CITY OF ALBUQUERQUE

July 10, 2018

RE: Tierra Serena (Glendesto) Subdivision
Lots 1-4, 7-12, 21-27 - Accepted
Revised Grading Plan Stamp Date: 1/23/18
Certification Dated: 6/28/18
Hydrology File: B18D020

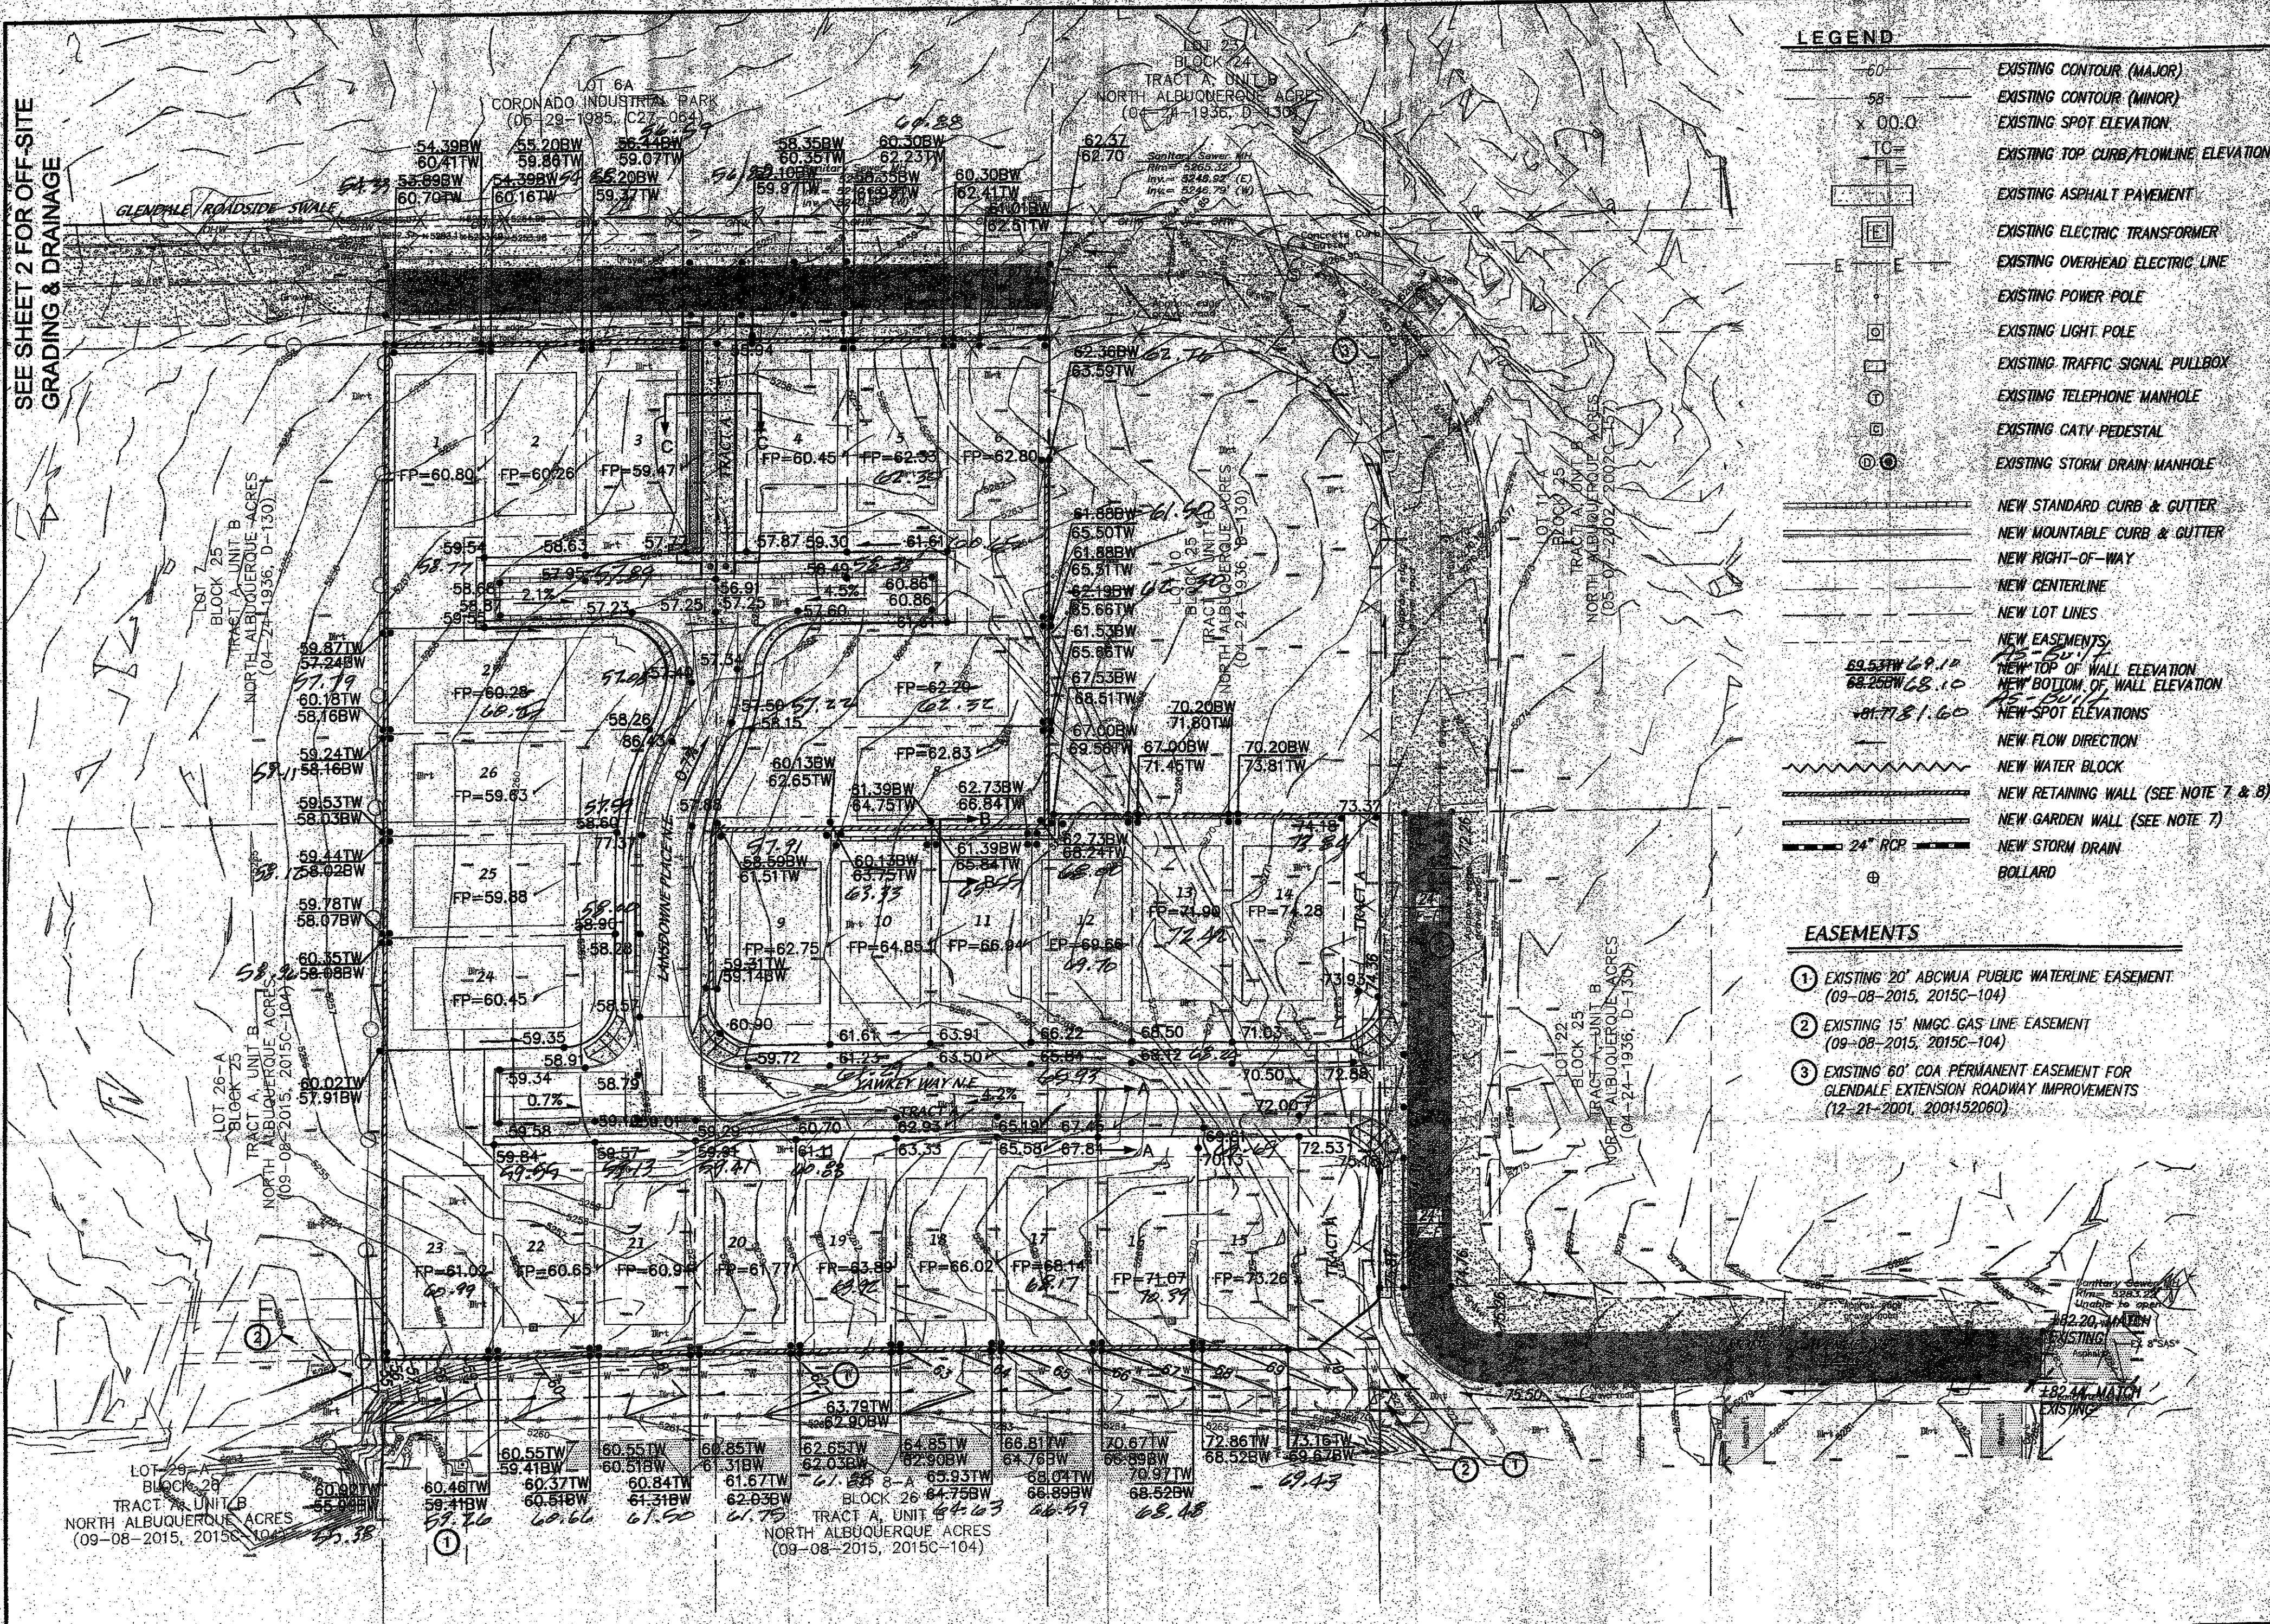
1. The Pad elevations are missing for Lots 14 & 15.
2. The cross-lot drainage between Lots 15-20 needs to be noted on the certification and corrective action taken to ensure these lots drain to the road.
3. The parking lot needs to be removed prior to certifying Lot 14.

4. All survey data required per the DPM Ch 22.7: *Engineer's Certification Checklist for Subdivision* will need to be provided for Lots 5, 6, and 13.
5. The downstream storm water conveyance must be complete.
6. The water and gas easement behind lots 15-23 needs to be restored. Fill placed against the wood fence needs to be removed and this area needs to be reseeded and stabilized against erosion with check dams and gravel mulch.
7. All other offsite areas distributed as part of this project need to be restored and reseeded as well.
8. Additional comments can be expected at the time of ROFG, depending on future conditions at this site.
